Your Reference: SSD 8800
Our Reference: NCA/8/2017
Contact: Myfanwy McNally
Telephone: 9806 5447

6 November 2017

Re: Request for SEARs – Parramatta Leagues Club Hotel at 1 Eels Place, Parramatta (SSD 8800)

1 EXISTING - 22 JUNE - 0900
1:1000

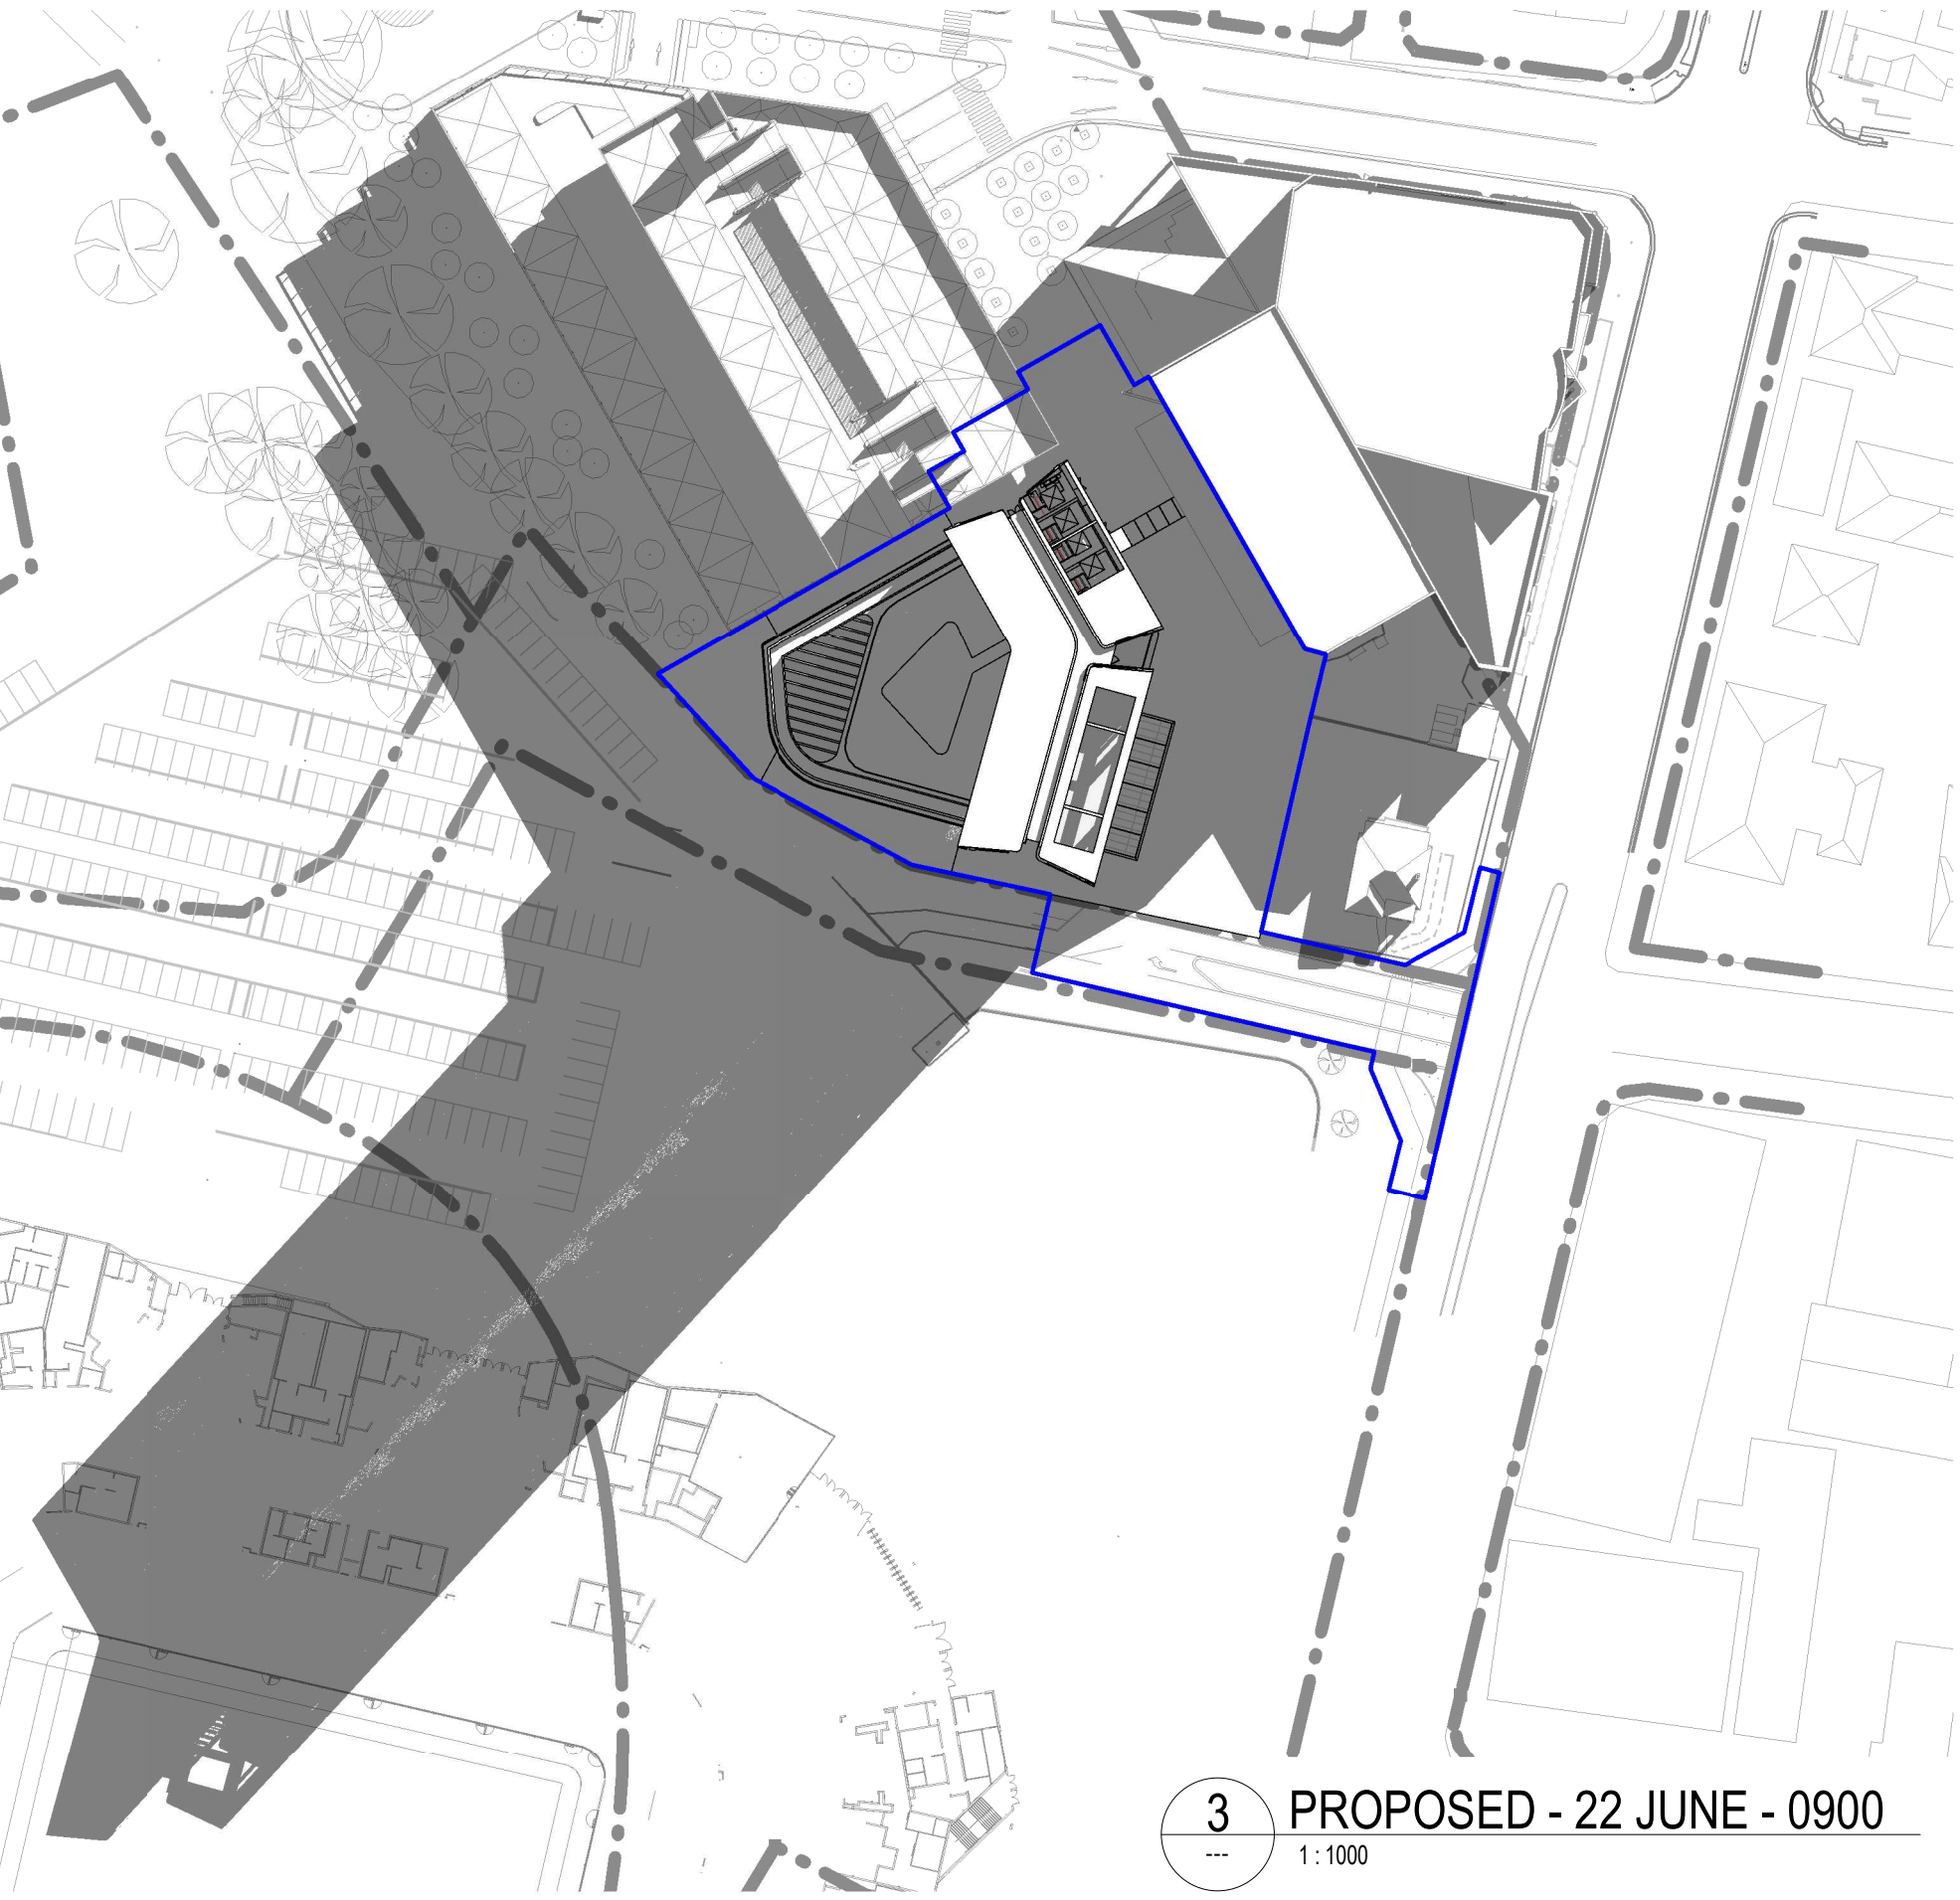
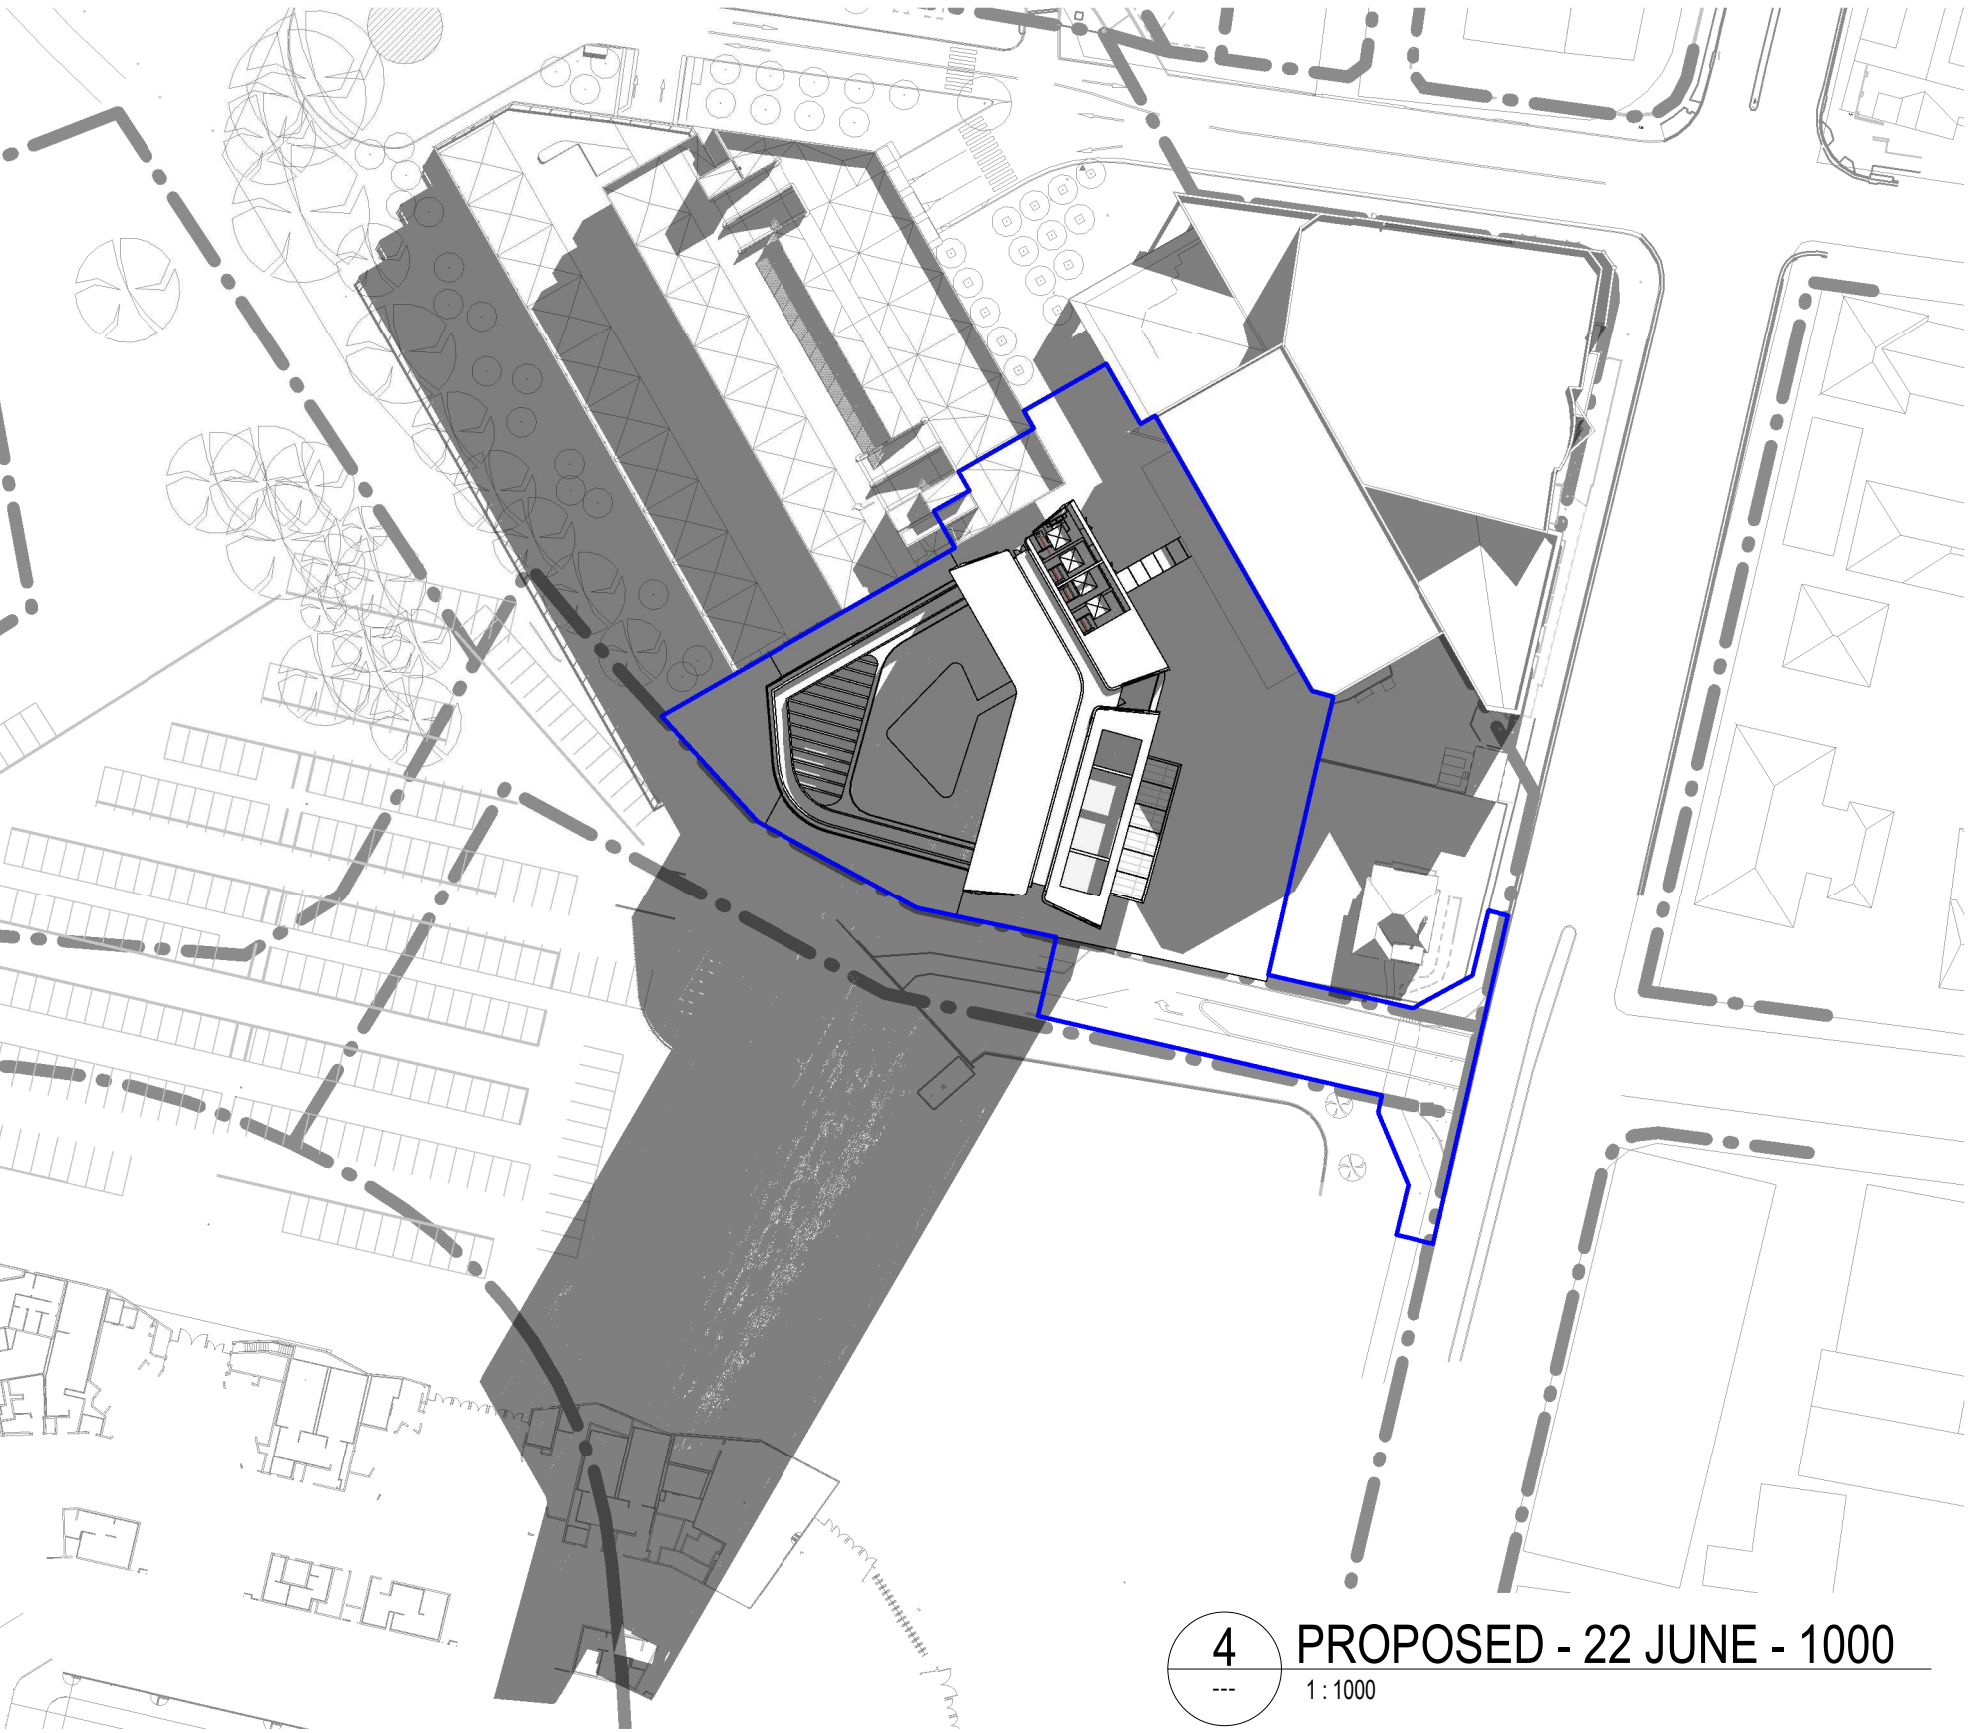
Hourly overshadowing plans should be included in the application for summer solstice, winter solstice and equinox. Diagrams are to clearly show the shadow impacts of the proposal on the surrounding sites and the public domain. Of particular note are the future Infrastructure NSW development and Parramatta Park located to the south of the site.
